From: Sue Howell
Sent: 23 January 2018 16:29
To: Planning.Responses
Cc: Ross Leal
Subject: RE: Please find attached amendment on planning application Ref: WA/76/17/PL

Comment from Greenspace

APPLICATION WA/76/17/PL

Description of Works: Application of four Affordable Intermediate Sale Homes and one Full Market home with associated car parking, garaging, landscaping and bin storage and the creation of 2 new accesses onto Wandleys Lane. This application is a Departure from the Development Plan.

T1, T2, T3, T4, T5, T6
AS ARUN DISTRICT COUNCIL
TREE PRESERVATION ORDER
TPO/NA/4/17 (2018)

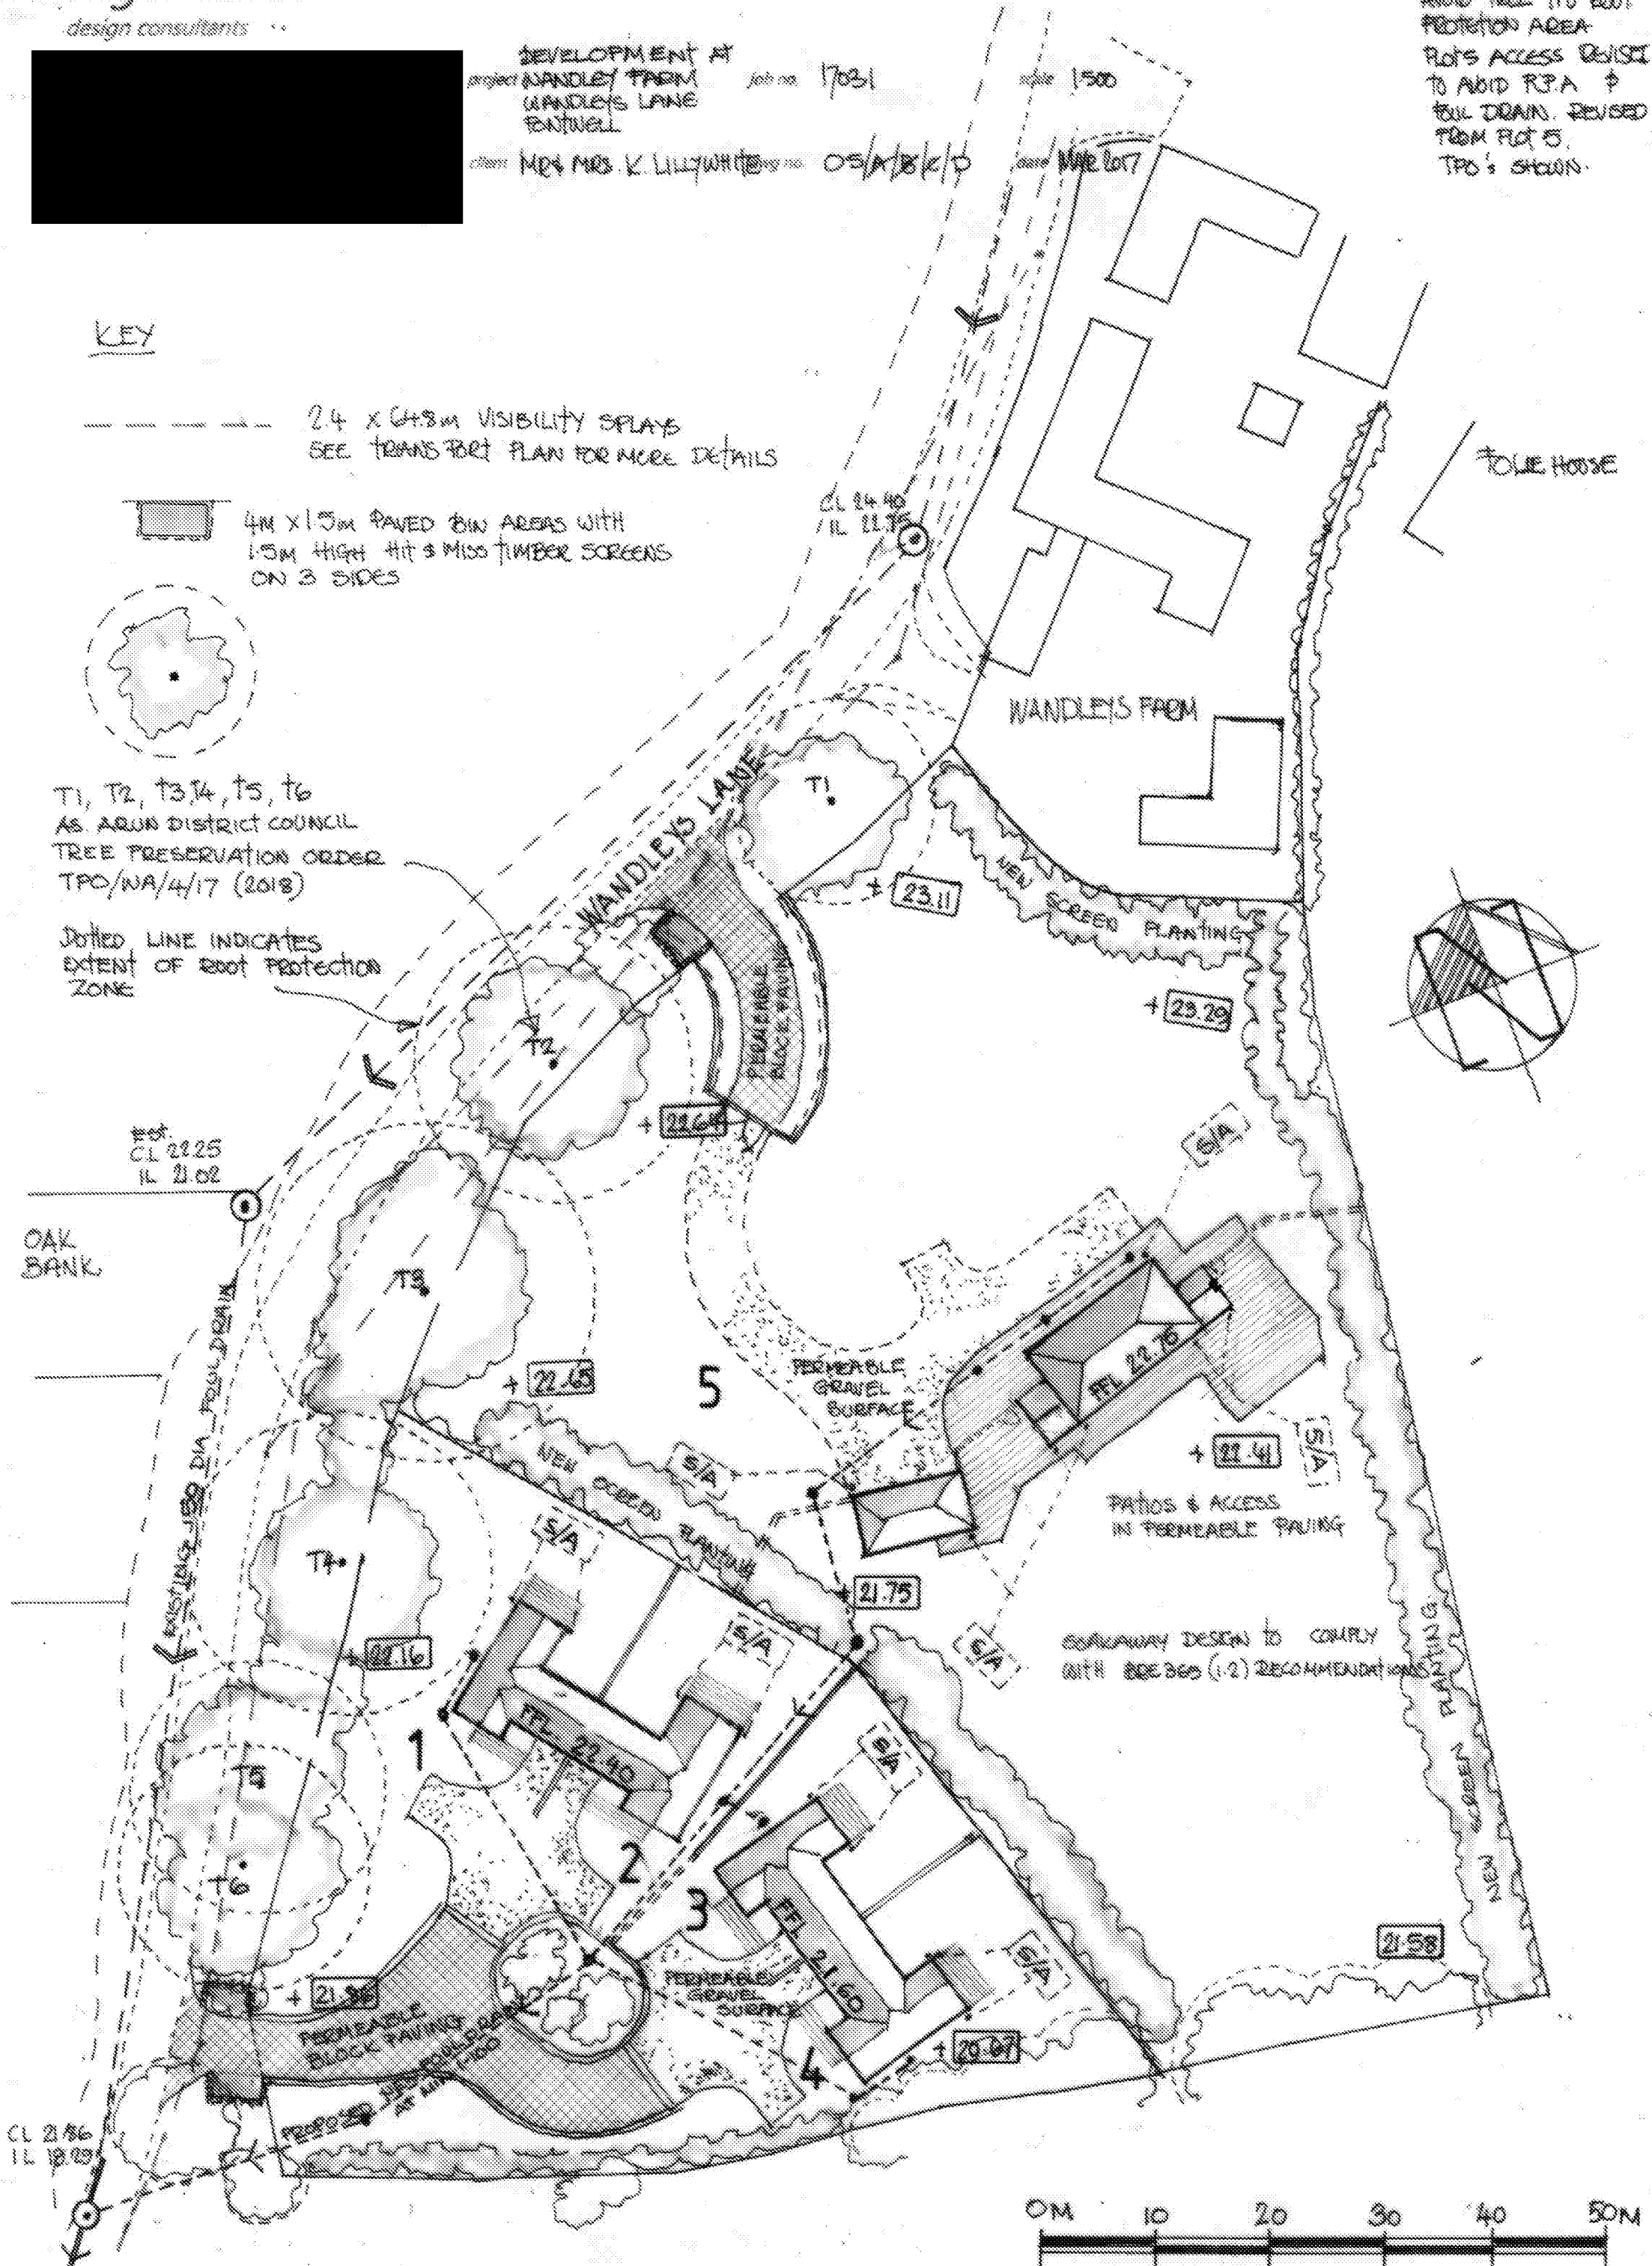
There are many trees to the boundaries of this application site and particularly to the proposed access points which should be considered within these proposals. Any proposed tree works to this site should be in consultation with agreed with Arun District Councils Tree Officer. The existing vegetation to the boundaries is established, these areas must be protected and retained. Before construction, this tree protection scheme must be in place for all retained trees including trees whose root protection areas fall within the construction zone. This should be in accordance with BS 5837:20012 'Trees in relation to construction' Any tree removal must be in consultation with Arun District Councils tree officer.

A detailed landscape scheme will need to be proposed that will maximise the biodiversity of the site in its semi-rural setting with the inclusion of mixed ornamental and native species for the retention of a variety of habitats. The landscape proposals will need to be shown in plan from detailing species choice, planting densities and size at time of planting. This will need to include mitigation planting for any proposed removed vegetation and additional planting would be required to provide potential screening to adjacent properties and mitigation tree planting for any losses.
